Planning statement for 10 Beacon Close, Uxbridge, UB8 1PX

Pre-Application Advice: Comments from the officer and Our Response:

Drawing Title  
 Ground Floor - Proposed

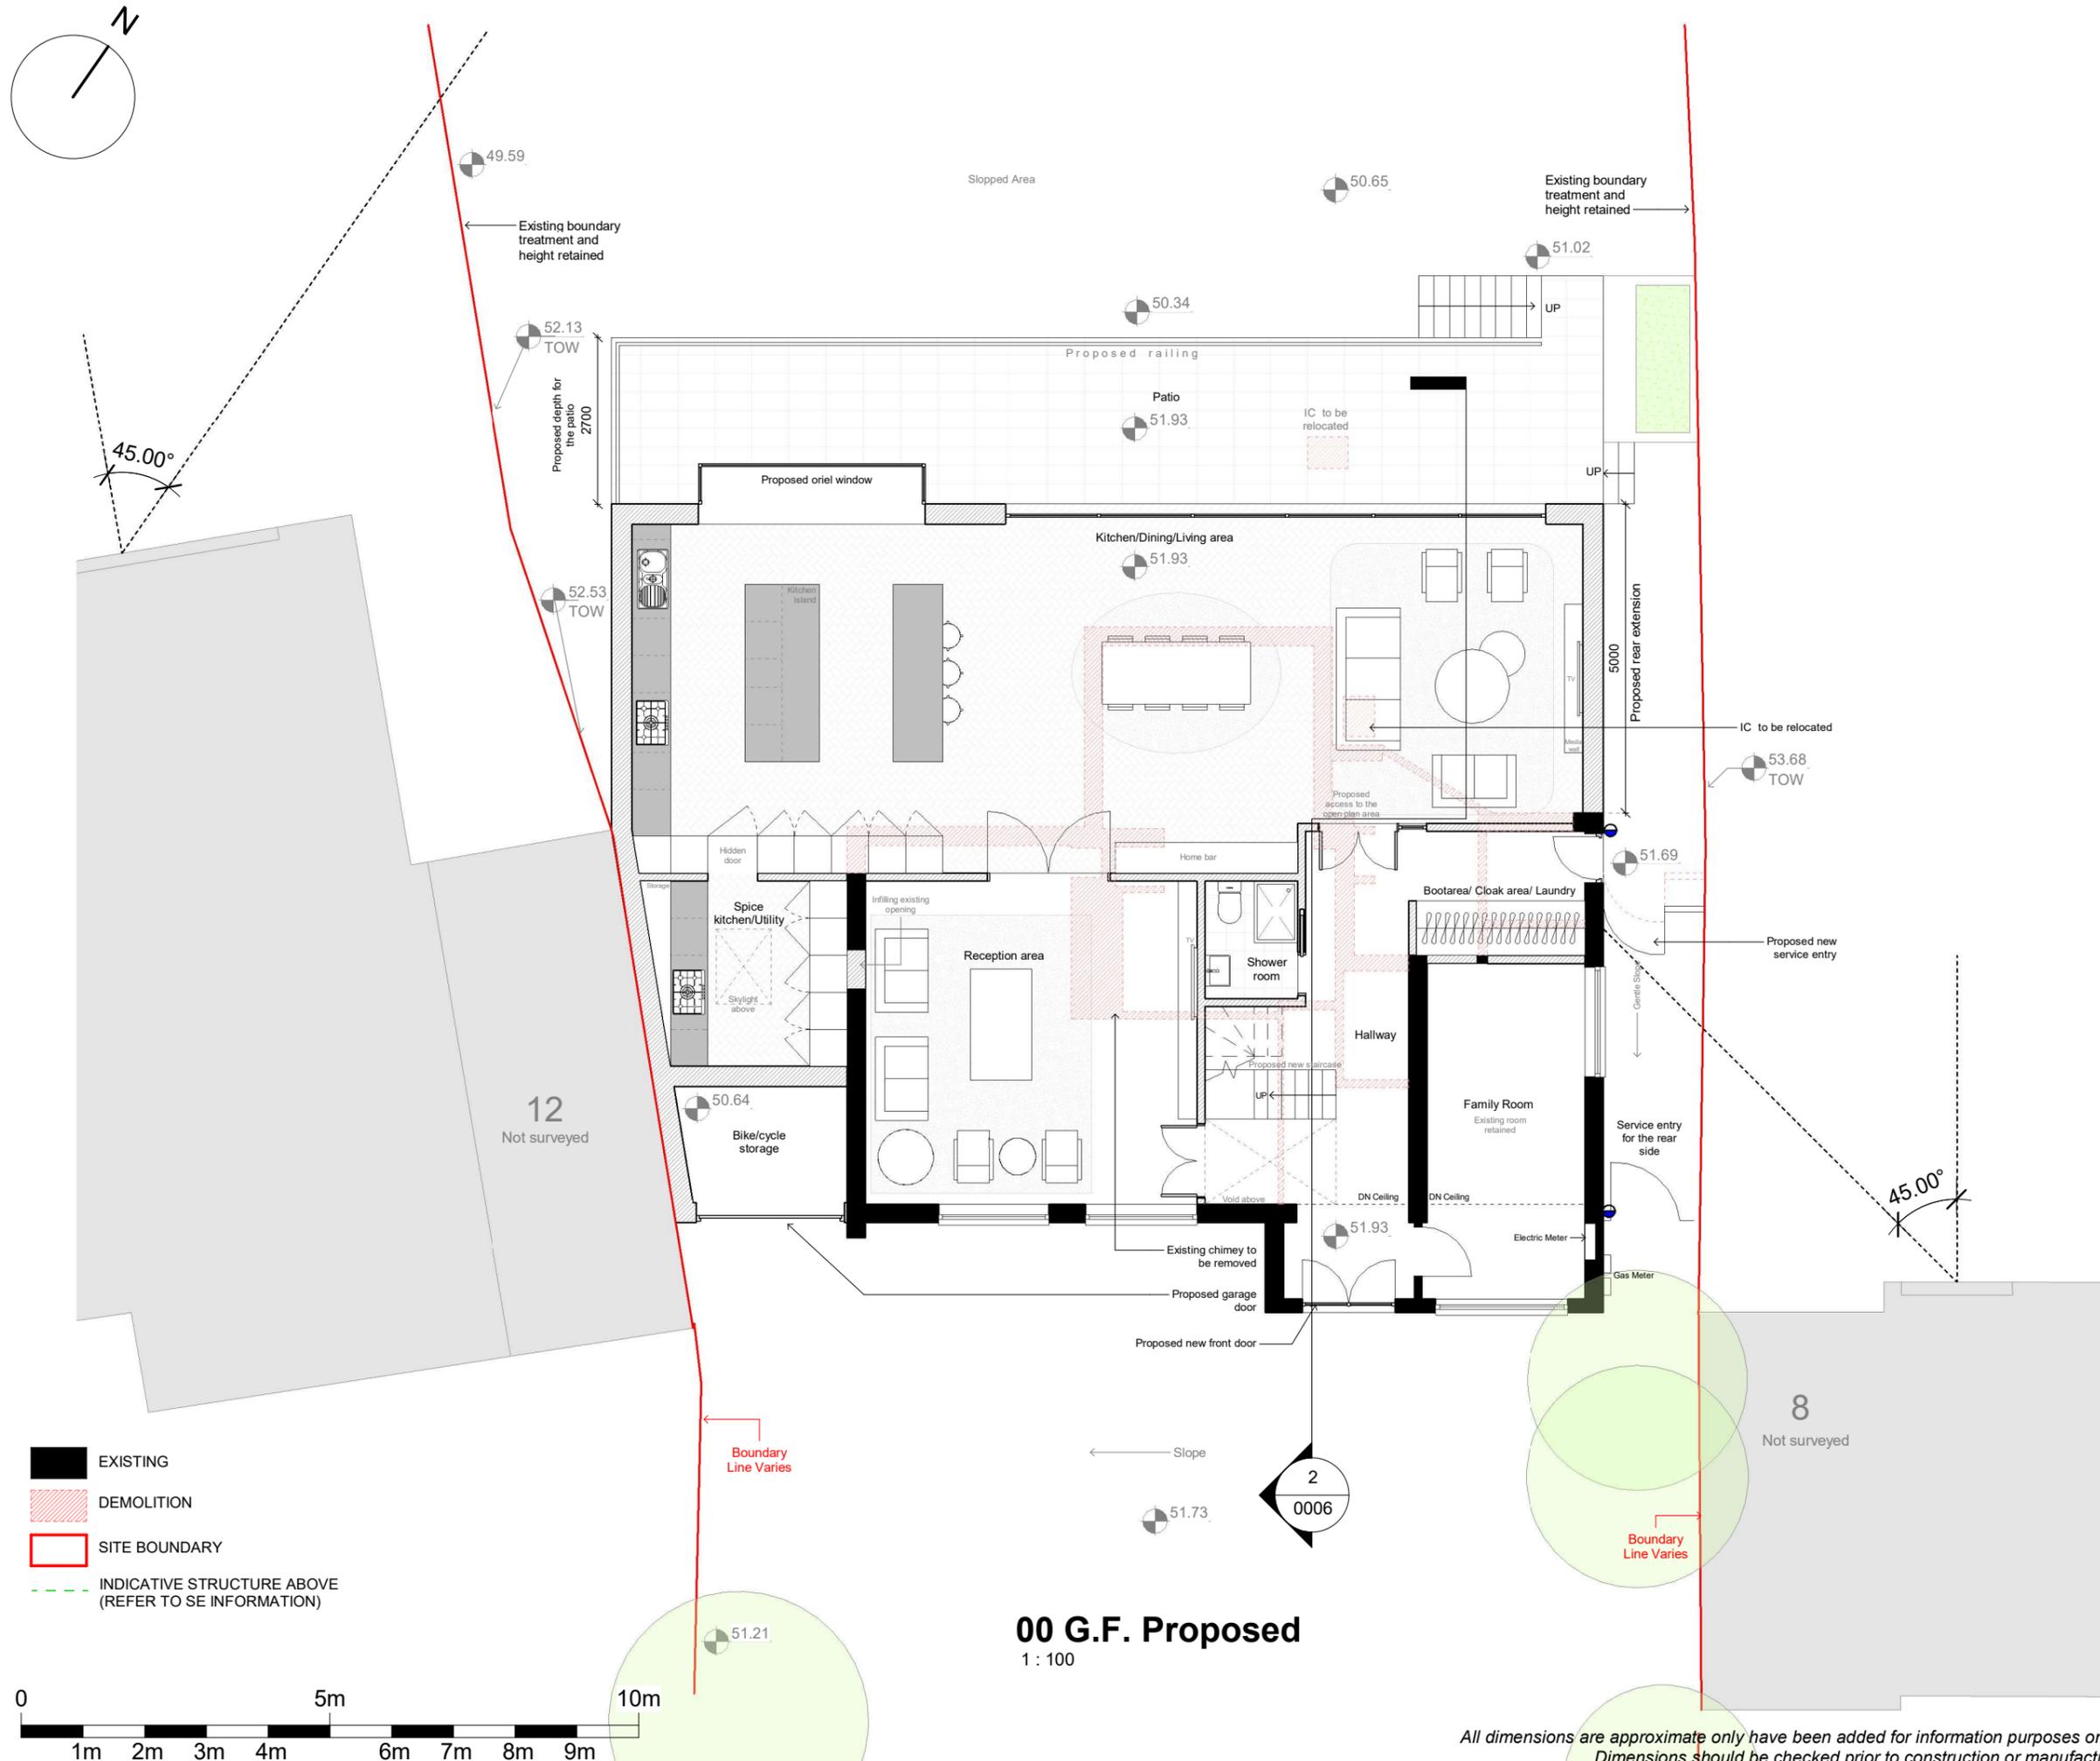
-The proposed depth of the rear extension would excessively extend beyond that stated within Policy DMHD 1. A depth of approx. 4-5m may be viewed more favourably.

The development involves changes to the rear garden levels and a new patio area. Some concerns are raised regarding potential overlooking of neighbouring gardens given the increase in height. Within any formal application, further information would be required to assess the impact of these level changes to the amenities of neighbouring properties including the height of boundary treatments etc.

Depth of the rear extension reduced to 5 m

Level changes have been provided through the submitted topographical survey, which has been updated on the existing and proposed levels on the ground floor plans. In addition, the existing boundary treatments and the height for it have been retained and shown on the drawings.

Drawing Title  
 First Floor - Proposed

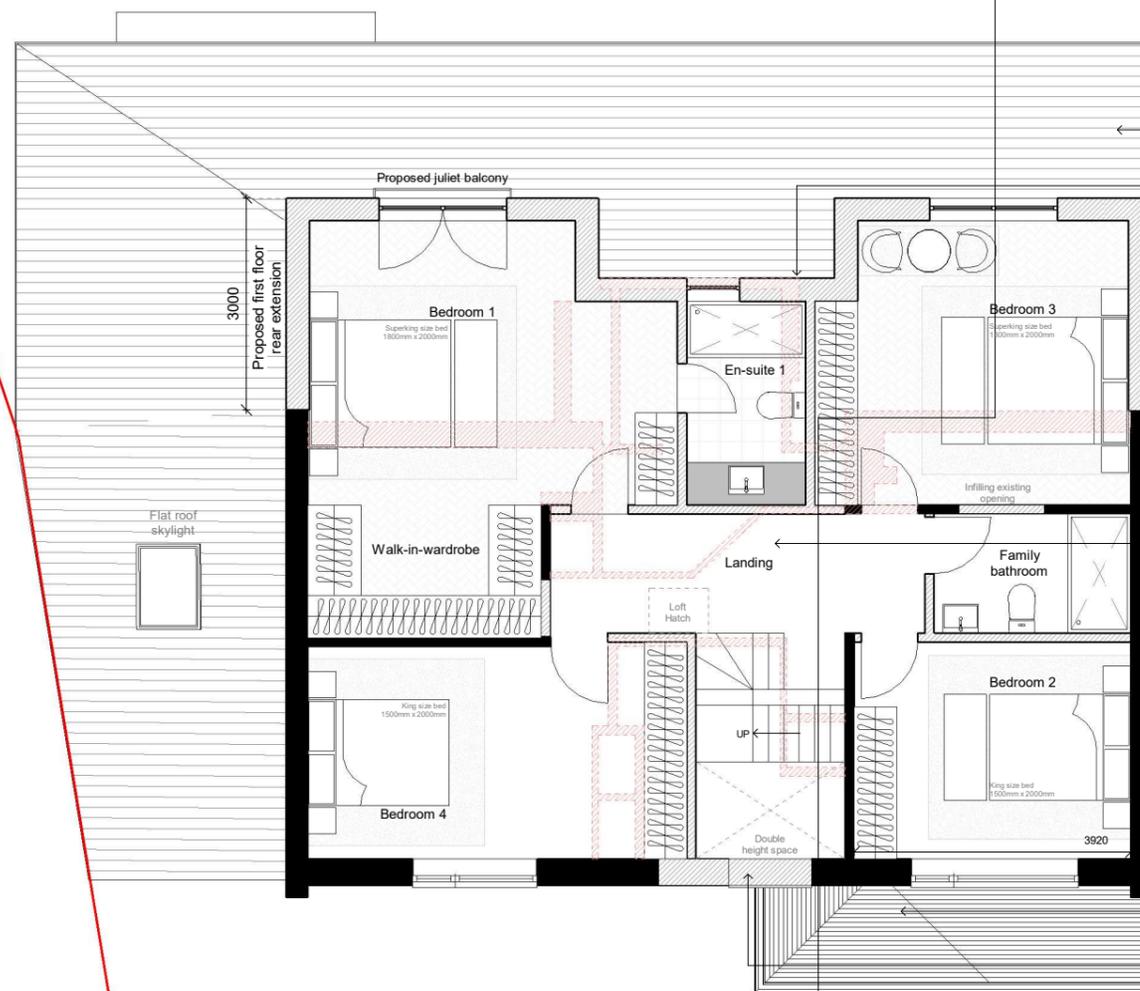
Whilst the extension is excessive in width and would alter the appearance of the rear of the property it is important to note two neighbouring properties numbers 12 and 14 Beacon Close that have benefitted from very similar extensions approved under applications 11959/APP/2016/3101 and 2719/APP/2019/908. Whilst it is acknowledged that both these neighbouring extensions were approved under the outdated local plan policies, weight is given to these examples given their proximity to the site. As the extension is located to the rear of the property and would not be visible from the street scene it is not considered that it would cause substantial harm to the character and appearance of the surrounding area. It is suggested that the middle gable is reduced in size to better reflect the developments at numbers 12 and 14 and to appear more subordinate.

Please note the middle gable external wall has been kept aligned to the existing gable wall itself

Drawing Title  
Roof Plan - Proposed

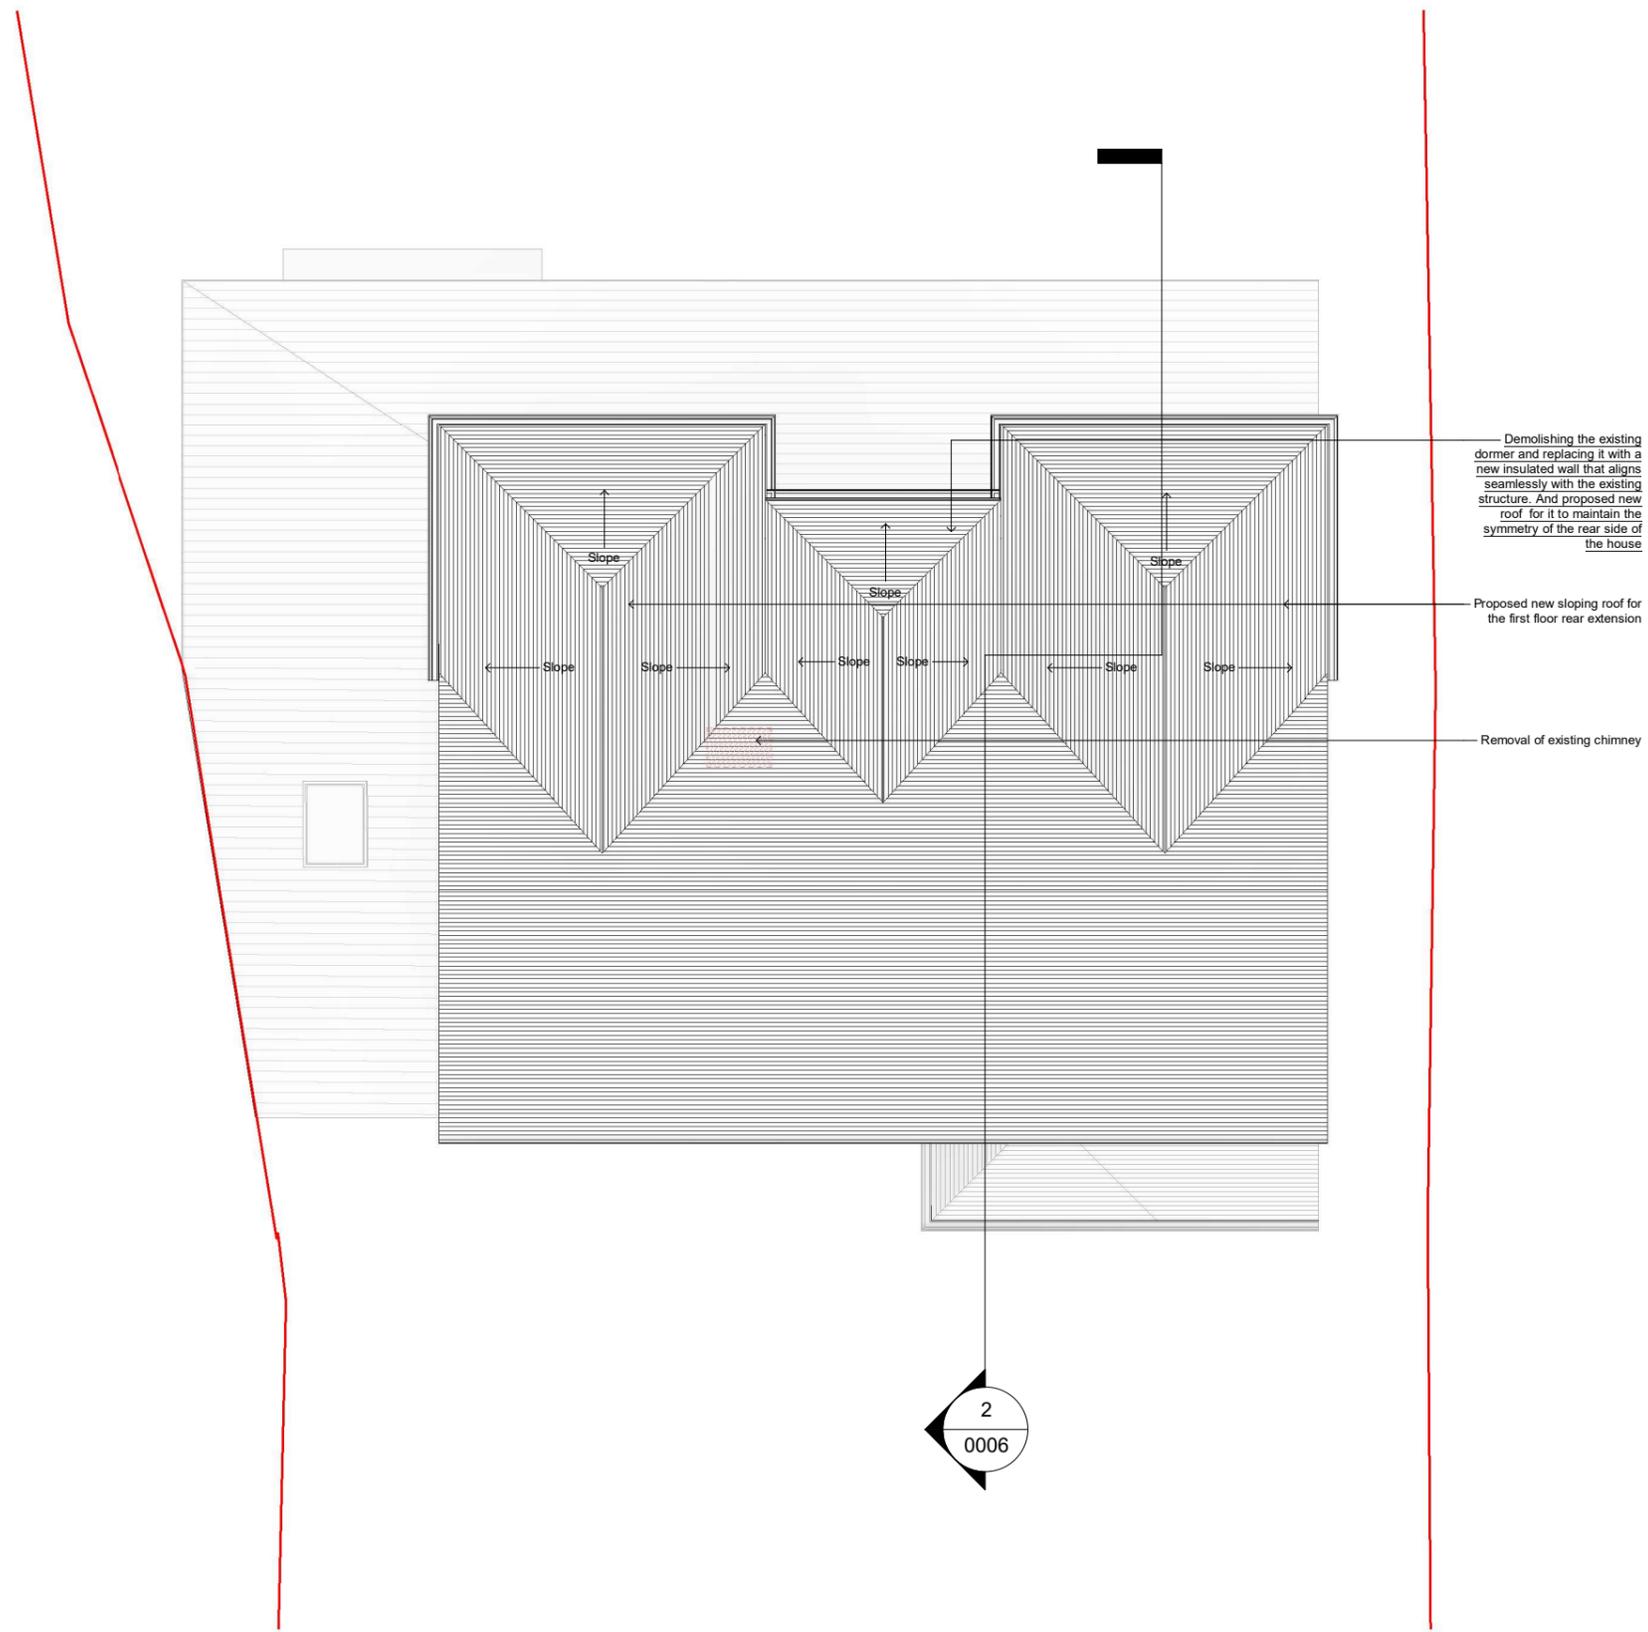
The existing property benefits from a front porch featuring a gable end roof to match the existing property. The development proposes to alter the existing roof form of the porch to include a half hipped, half gable end roof; there would be no increase in height or footprint

Proposed porch design retained as submitted in the pre-application
